# SUPERSTAR CARWASH

## MEADOWBROOK PKWY

Grading and Erosion Control Plans (standalone)

Add EPC's EDARP File Number: PPR2315

C3.0

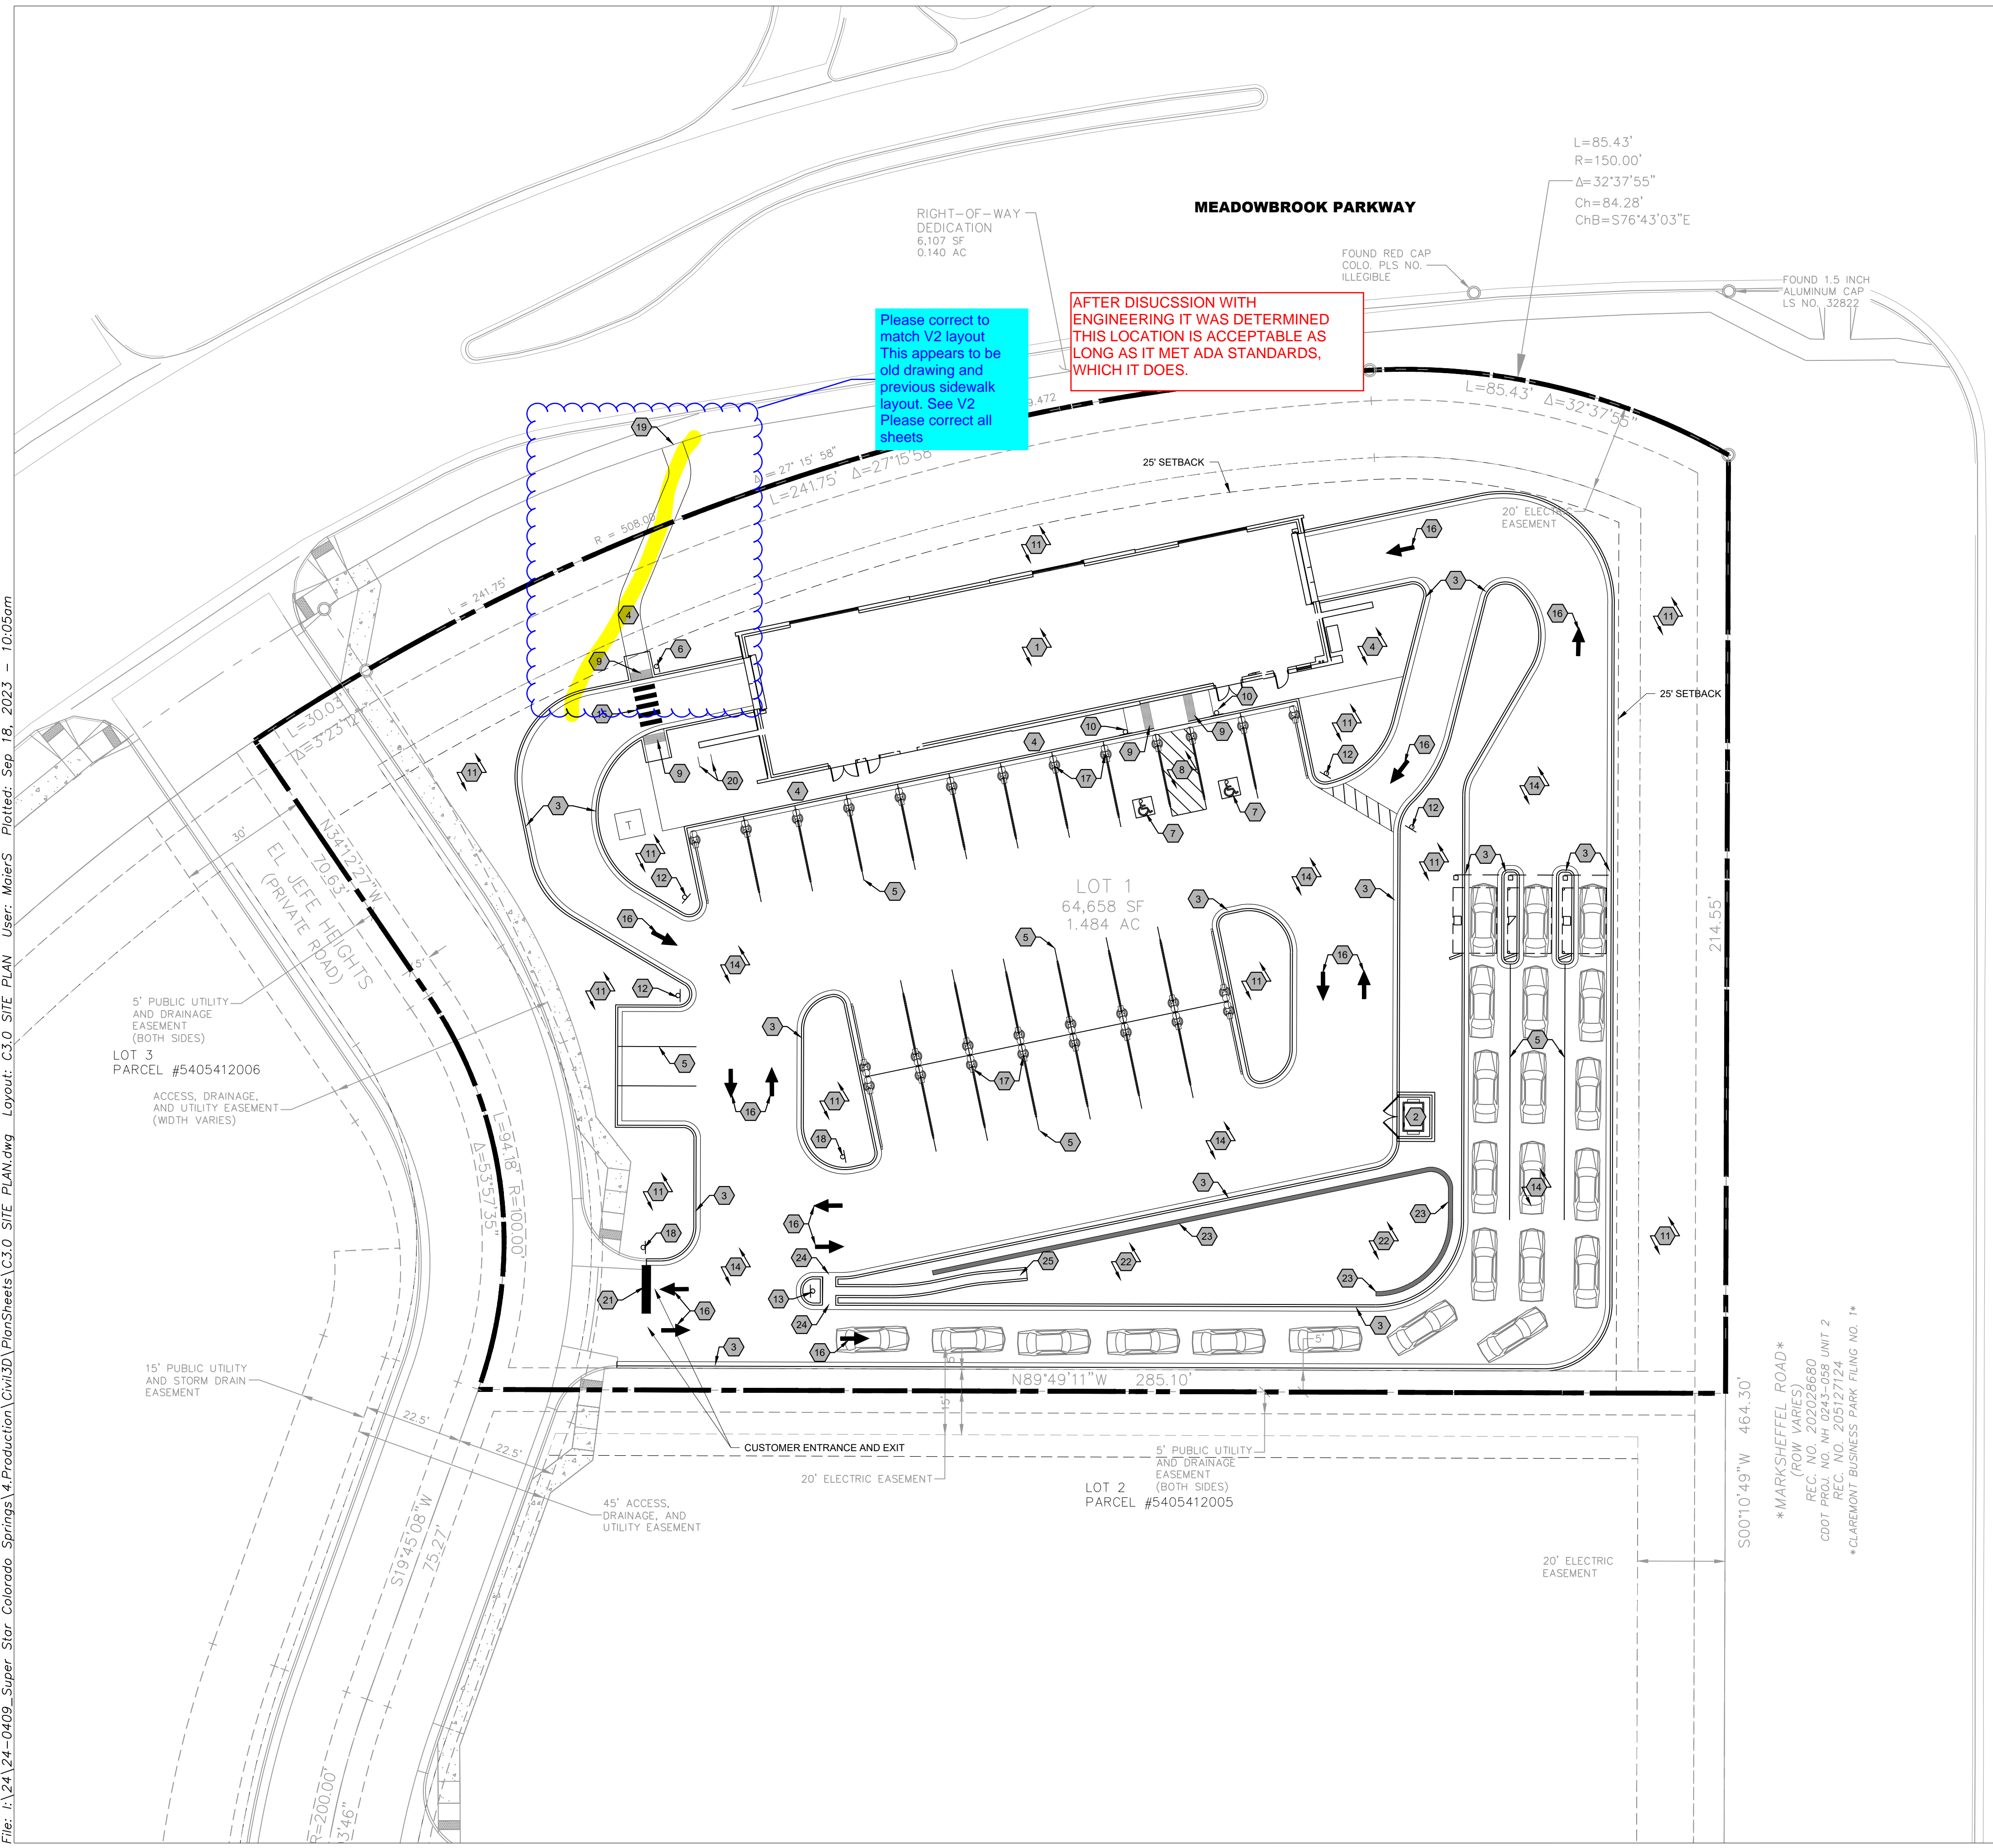
Please show the proposed signs for the cash wash too

Please depict garbage receptacles and screening mechanisms

Any fencing or walls ? please include height

Provide a line legend

Show proposed storm drain system throughout site.

Ensure CD plans set for VR233 is corrected for PED ramps

Label as urban local road class (PVT) road width 45ft

Please label the sidewalk and PED ramps. Is this to be installed with the concurrent vacate replat project. Please clarify

Call out 6ft wide crossspan per EPC Std. CDs had error with 3ft

Add road class and ROW width Collector 80ft ROW (Public)

Call out existing sidewalk

Include width of sidewalk too

Consider sidewalk realignment

Correct PED ramp connections across Meadow Brook and to existing sidewalk (all sheets)

show connection (all sheets)

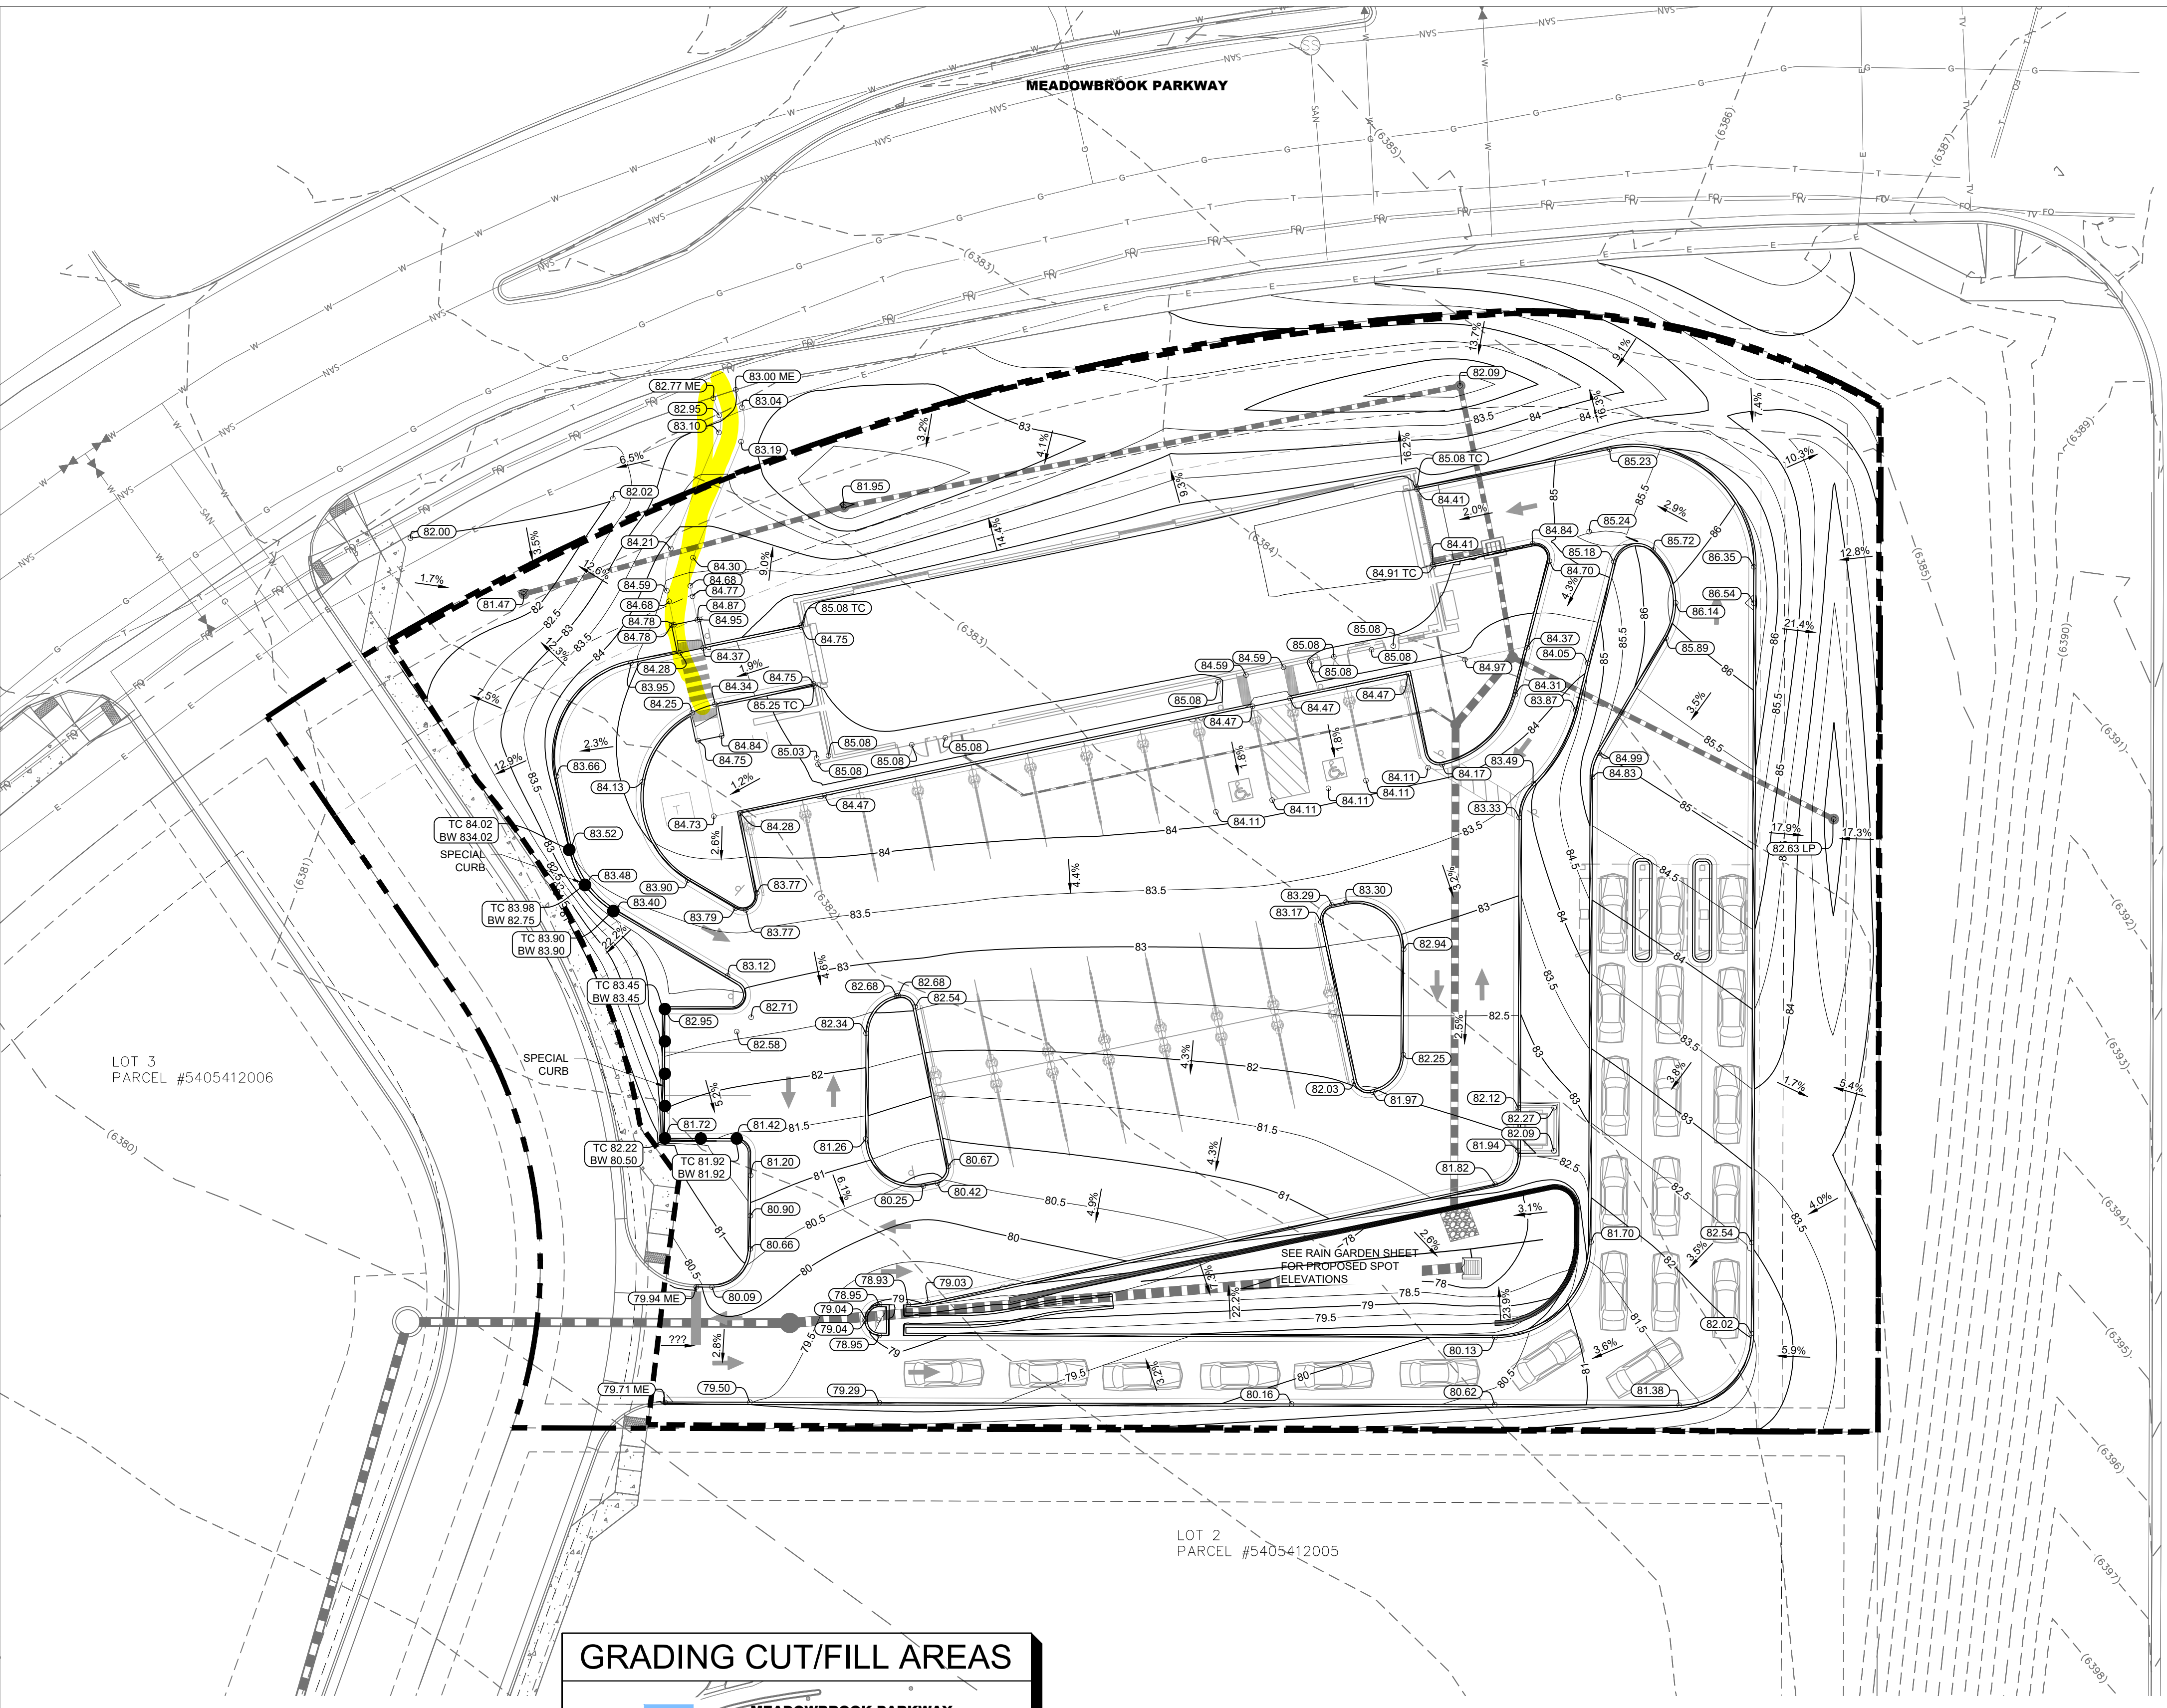
Add flow arrows to entire sheet not just the parking lot/car wash area.

GEC Checklist Item b - Label all adjacent property parcel numbers.  
GEC Checklist Item e - Show all R/W and property lines as well as subdivision boundaries.  
GEC Checklist Item t - Add note stating there are no dedicated asphalt/concrete batch plants.  
GEC Checklist Item bb - Show and label exist and proposed permanent stormwater management facilities, including areas proposed for stormwater infiltration or subsurface detention.

GEC Checklist Item x: TSBs required for disturbing greater than 1 ac.

GEC Checklist Item v: Label all proposed temporary construction BMPs by phase of implementation (initial, interim, final).

The drainage report does not clearly state this. Add text to the drainage report to clarify and demonstrate that the pond was designed to have capacity for the fully developed site.

State the percent of ground cover on site. This will be required per the SWMP and checklist.

Label all storm drains, are they existing? Proposed?

These signature blocks are for standalone GEC Plans. If these are to be used you will need a separate GEC cover page and the set should be separate from the rest of the construction drawings.

Combine Erosion Control and Grading plan. To create one GEC plan.
